**PLANNING APPLICATION: 2022/93563**

**Outline application for erection of residential development; New North Road,  
Heckmondwike, Kirklees, WF16 9DW**

I have reviewed the proposals and confirm that part the application site falls within the defined Development High Risk Area; therefore within the application site and surrounding area there are coal mining features and hazards which need to be considered in relation to the determination of this planning application.

SITE PLAN 1:500

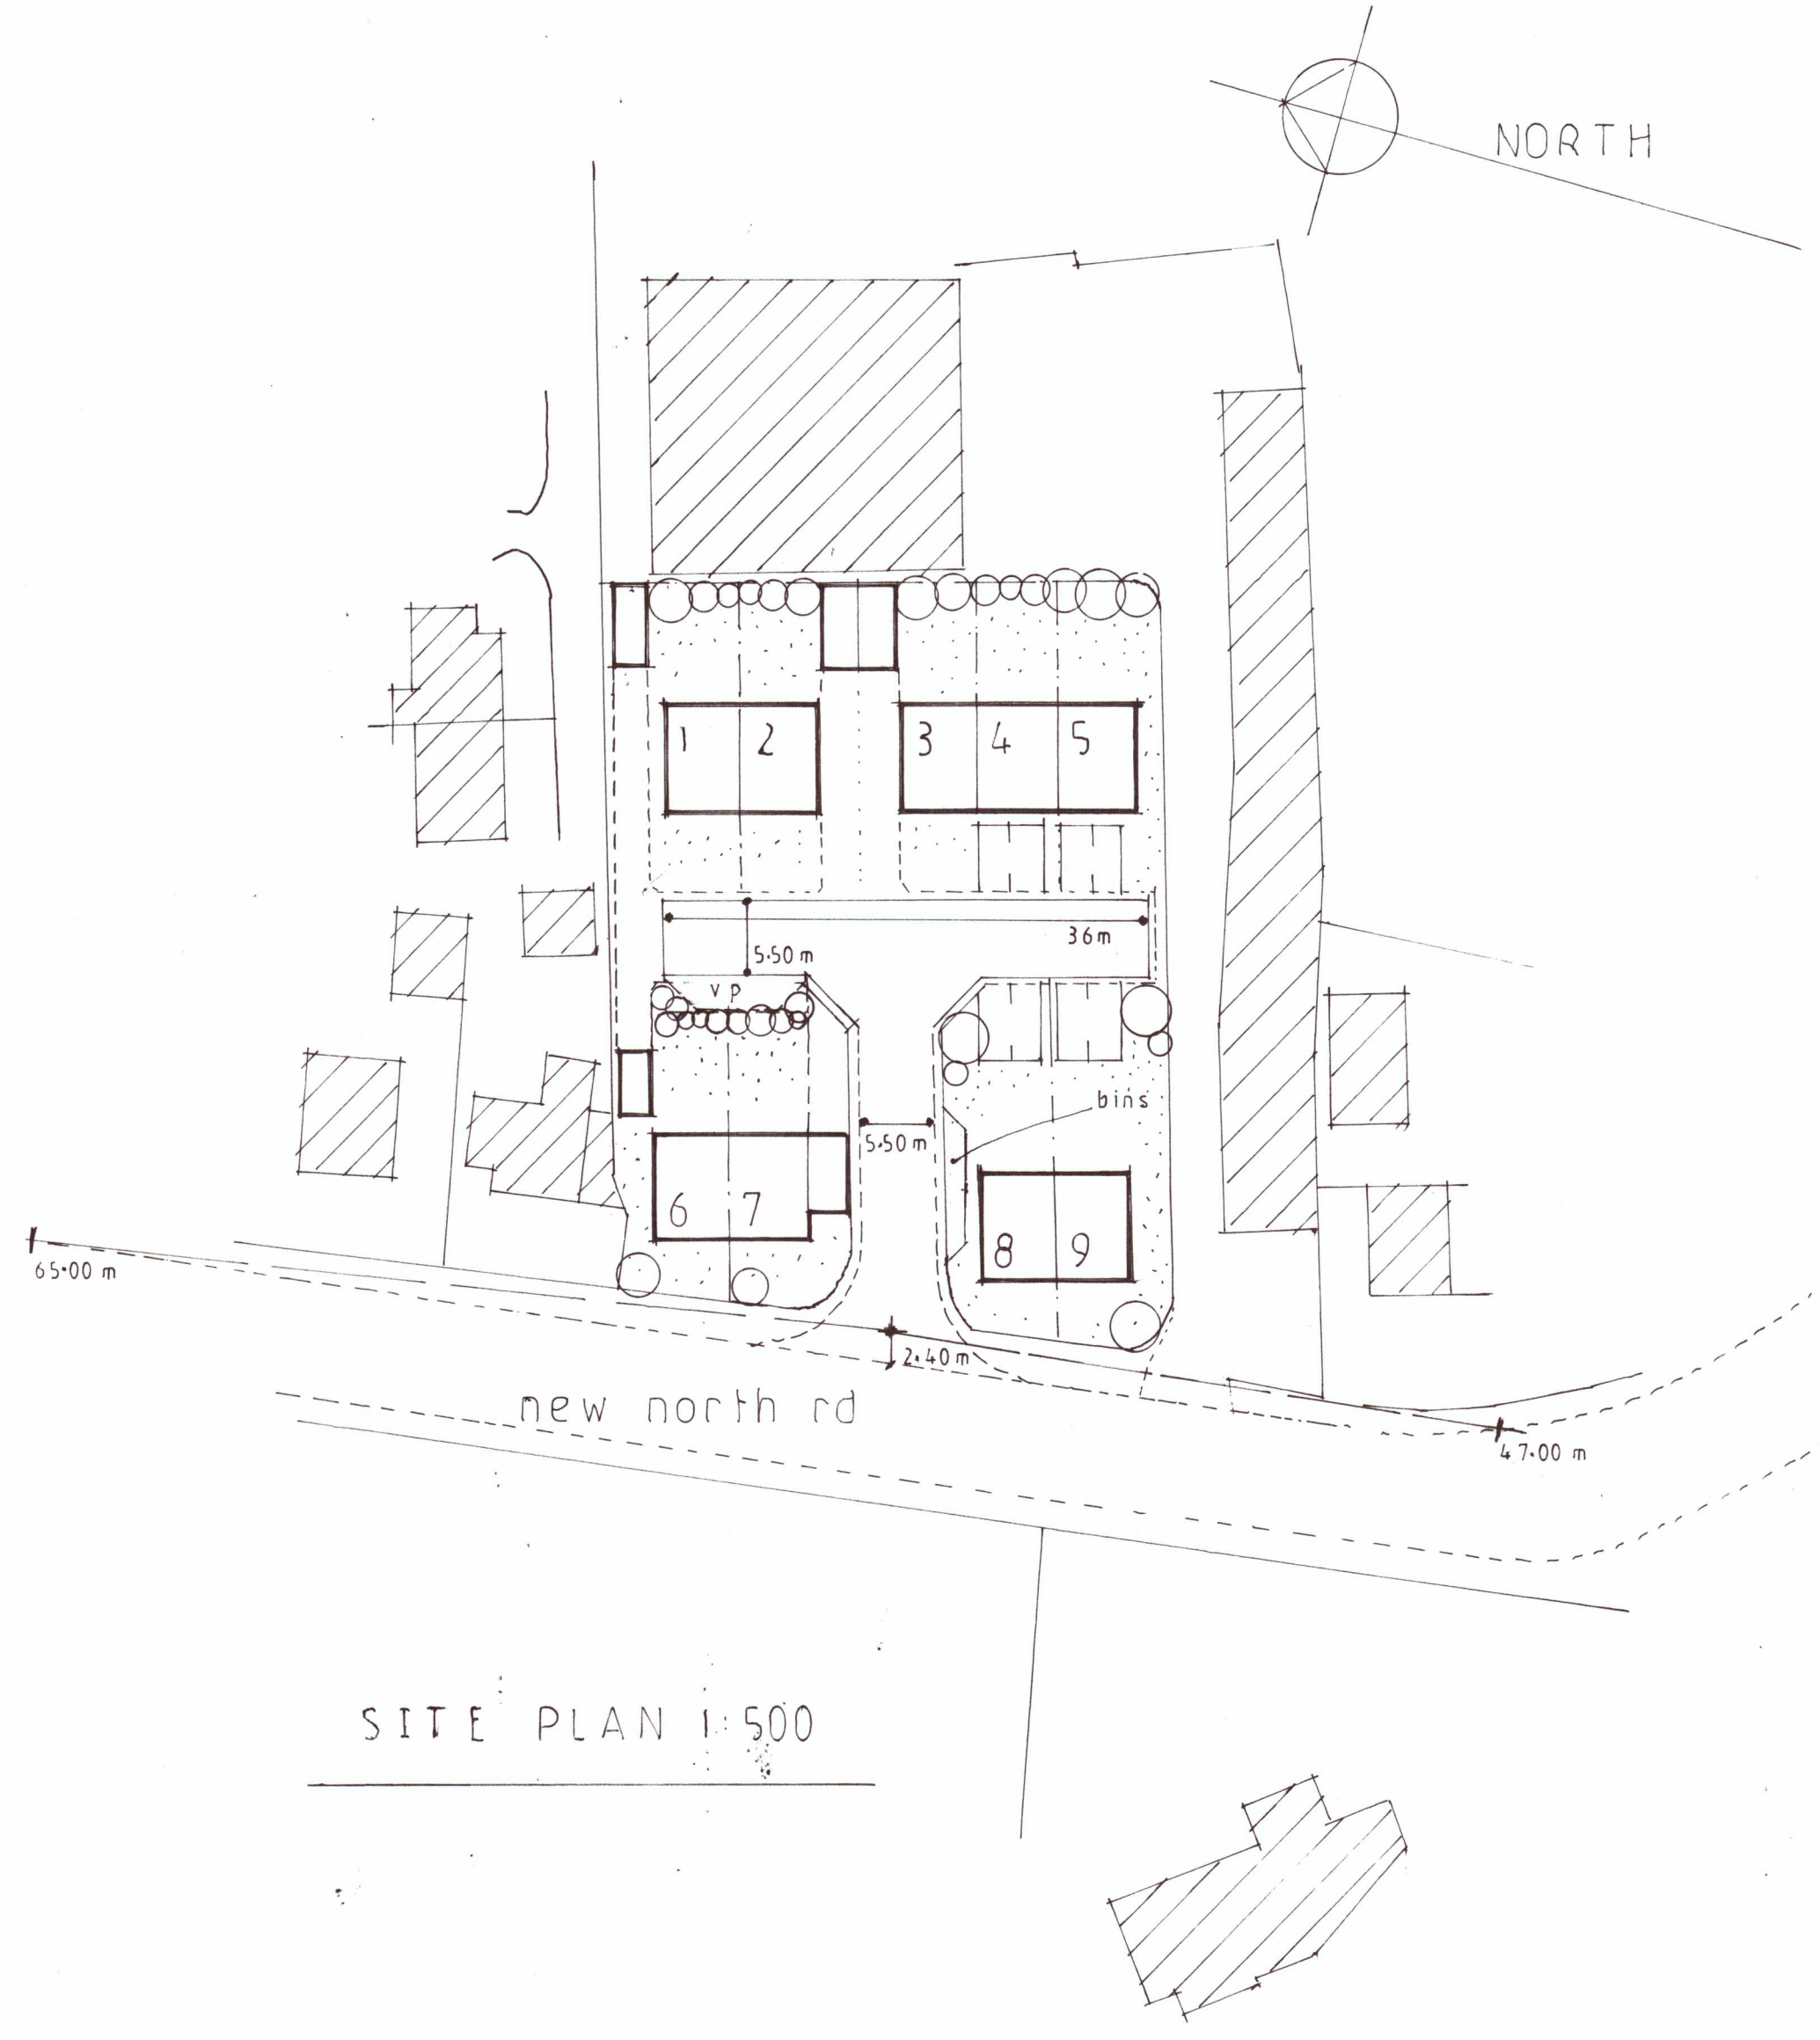
Having carried out a review of the available information, the report author concurs with our records and considers that whilst it is unlikely that the mine entries are present within the site, prior to construction, a surface strip is carried out to the footprints of Plots 8 and 9, and the front garden areas of these plots.

Whilst an appropriate assessment and mitigation strategy has been provided, we consider that the above investigations to confirm the absence of the mine entries within the site should be carried out prior to the submission of the reserved matters application. In the event that the mine entries are found within the site, the layout will need to be informed by these features to ensure that adequate separation between buildings and mine entries are incorporated in order to comply with our adopted policy (above). If the mine entries are not found, the worst-case scenario should be adopted that the mine entries are just outside the site boundary. The applicant's geotechnical consultant should be able to calculate the zone of influence (no build zone) of the off-site mine entries based on the ground conditions encountered. The findings of the investigations should also inform the extent of any remedial and / or mitigation measures required to ensure that the development, as a whole, is safe and stable.

1. **Prior to the submission of the reserved matters application** intrusive site investigations, identified by Michael D Joyce Associates LLP (report author of the Coal Mining Risk Assessment Report (4162, December 2022) have been carried out on site to establish the risks posed to the development by past coal mining activity (mine entries).

2. **As part of the reserved matters application** a report is submitted based on the findings of the site investigation works including an appropriate scheme of remedial and mitigation measures, if required. This should include the submission of the proposed layout plan which identifies the exact location and co-ordinates of the recorded mine entries, if found within the site, and the zone of influence (no build exclusion zone) of any mine entry within influencing distance of the site.
